Traffic Engineer's Statement

Re: Crossroads Mixed Use Traffic Study Letter (PCD File No. P208 and SP2011)
SWC of Meadowbrook Parkway and Newt Drive
El Paso County, Colorado

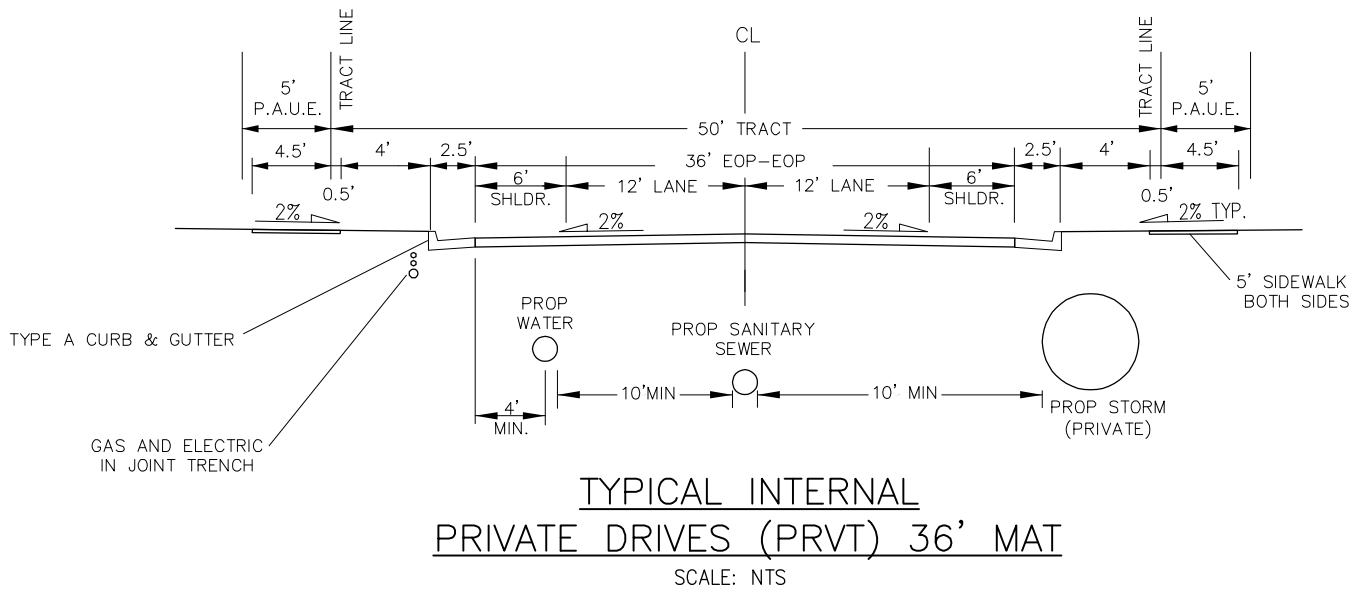
Per criteria this warrants exclusive left and right turn lanes. Revise the preliminary plan street layout to allow restriping for a second outgoing lane or submit deviation request for consideration.

Unresolved.

A deviation request was not included with the 4th submittal.

In reviewing the private road there appears to be room to reconfigure the cross section to fit the two separate turn lanes on the 36' pavement width (3x 12' lanes).

If you rescind the deviation request, then update the TIS narrative by identifying the phasing for the left turn lane. Include the following:

- 1. Identify in the short range horizon lane configuration such as either to a) chevron stripe the left turn lane or b) stripe per the standard cross section provided. (Add the cross section in the preliminary plan if you are going with "a")**
- 2. Identify the long range horizon lane configuration to include how long this separate lane should be (provide the cross section in the preliminary plan).**
- 3. Identify the trigger/warrant for installing the separate left and right turn lane. Seems likely to be when Marksheffel/Peterson connection is made.**
- 4. Identify who will be responsible to restripe the entrance once it's warranted.**
